Our ref: SSD 8699

**Staged Redevelopment of Greenwich Hospital (Concept Proposal) (SSD 8699)  
97 - 115 River Road, Greenwich – Response to Submissions**

## ATTACHMENT 1

TREE REMOVAL LEGEND

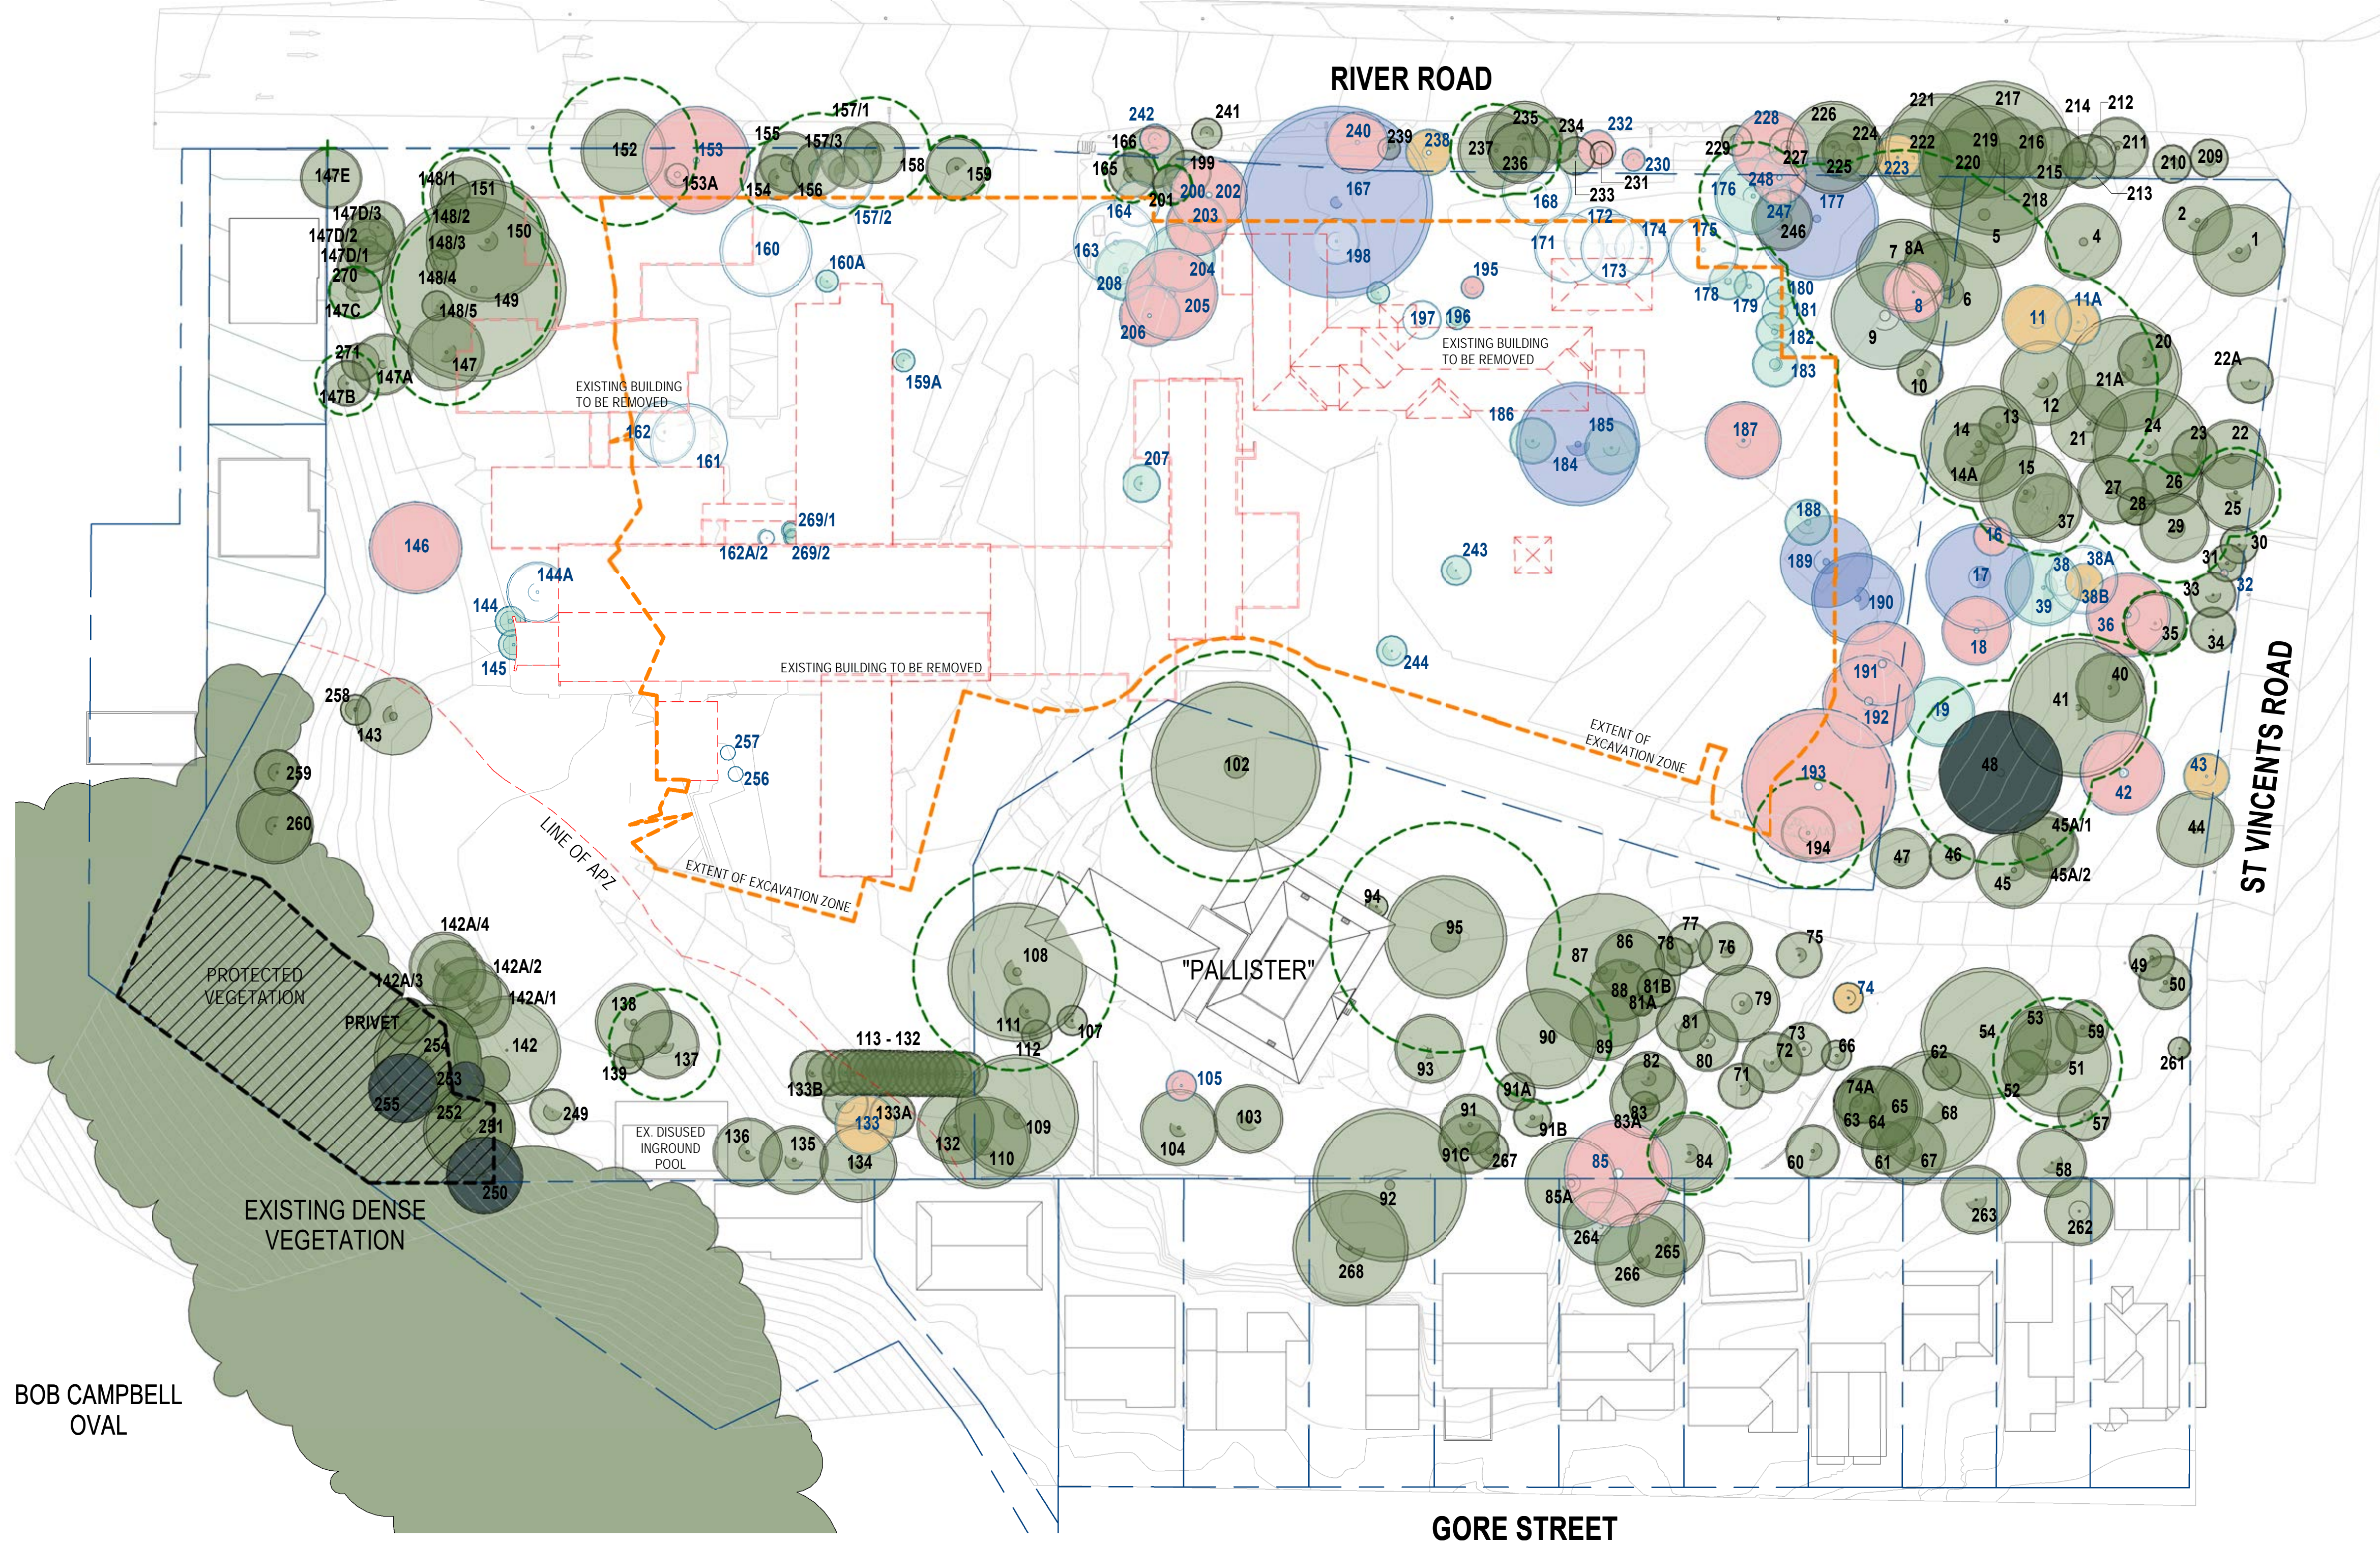
*A clear landscape plan indicating which trees will be kept and removed is required to understand the extent of change on the site.*

2 ROUTE TO BUS STOP
1 : 250

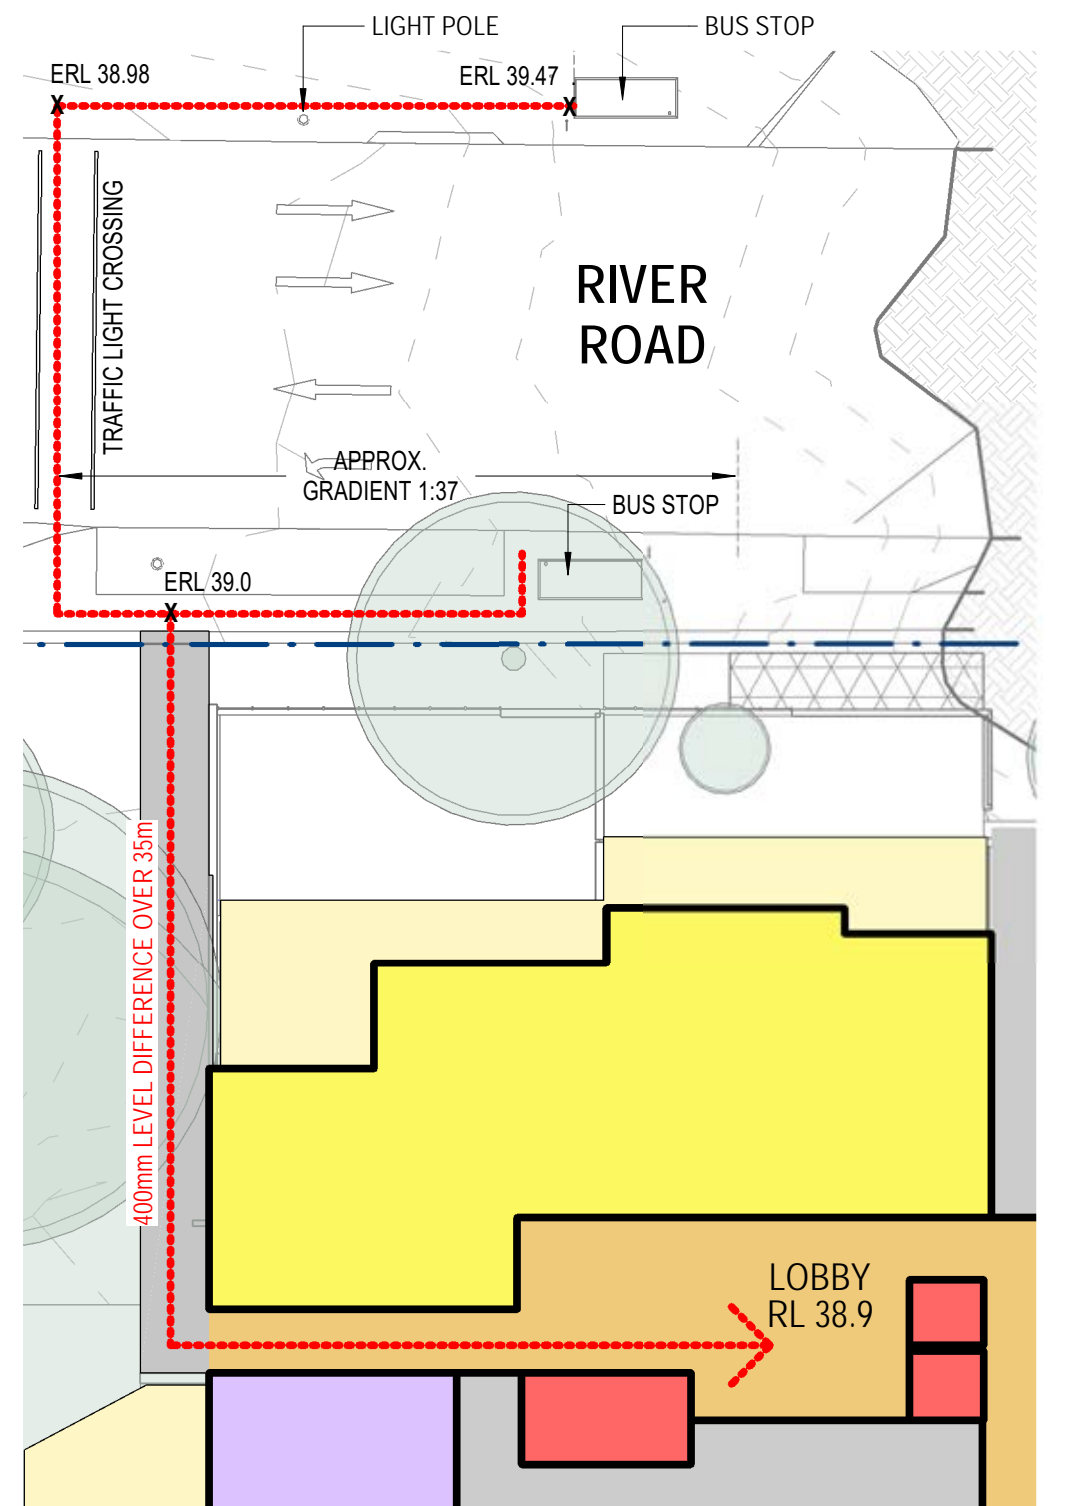
The RtS must demonstrate compliance with the location and access to facilities requirements of SEPP (HSPD). This includes identifying the relevant bus stops for each seniors housing building; demonstrating that a 'suitable access pathway' is available to the bus stops which meets the gradient requirements of SEPP (HSPD); demonstrating that the relevant bus stops are DDA compliant (see comments from TfNSW); and demonstrating that the facilities which must be available to residents are located at a distance of not more than 400m from the destination bus stop.

It is unclear how compliant gradients will be achieved given the topography of the site and slope of River Road.
